<b>Application Ref:</b>	3/2026/0084			 Ribble Valley Borough Council <small>www.ribblevalley.gov.uk</small>
<b>Date Inspected:</b>	N/A	<b>Site Notice:</b>	N/A	
<b>Officer:</b>	MC			
<b>DELEGATED ITEM FILE REPORT:</b>				<b>REFUSAL</b>

<b>Development Description:</b>	Certificate of Lawfulness for proposed access track to septic tank.
<b>Site Address/Location:</b>	Megitta House, Kenyon Lane, Langho, BB6 8AN

Figure 15: Map annotated by Officers provided by email dated 8th August 2025.

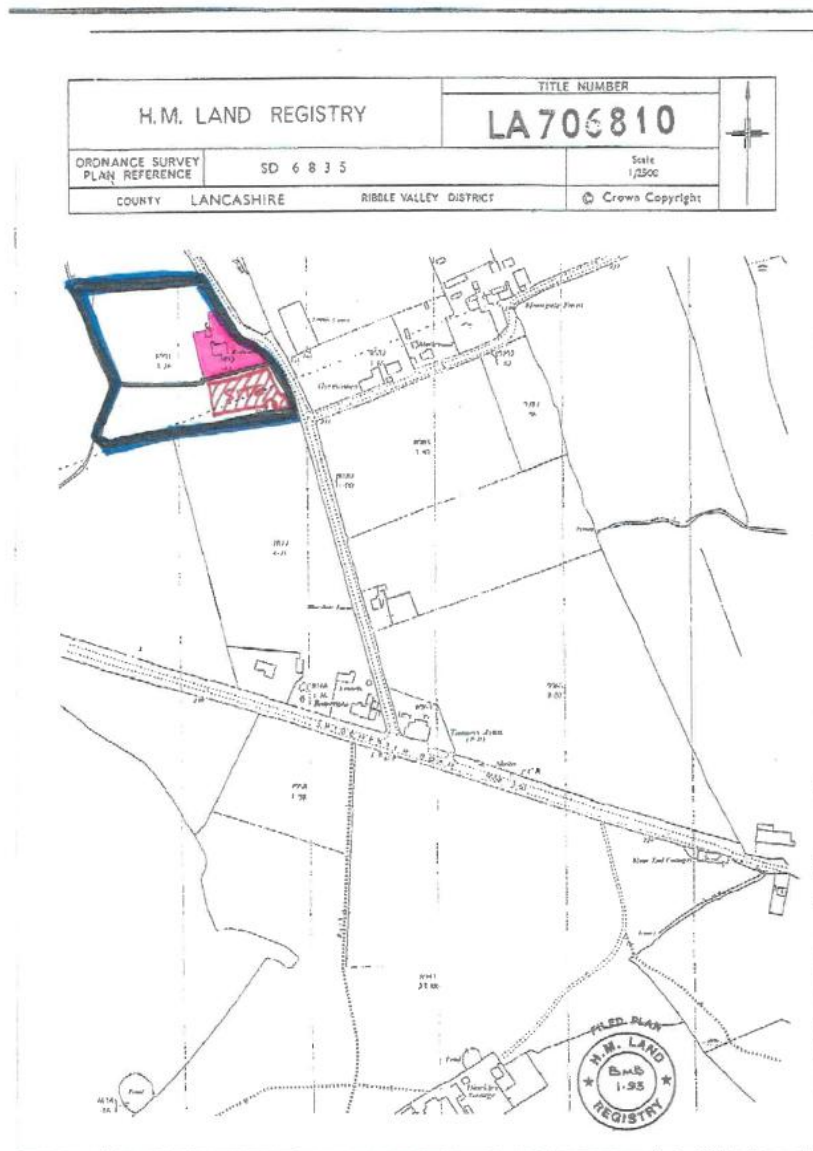
The Council consider that the land shaded in pink within figure 15 of the applicants planning statement is a closer reflection of the extent of land that should be treated as curtilage, and clearly the proposed track sits well outside of this area. As such, the proposal does not fall to be assessed under Schedule 2, Part 1, Class F of The Town and Country Planning (General Permitted Development) (England) Order 2015 (as amended).
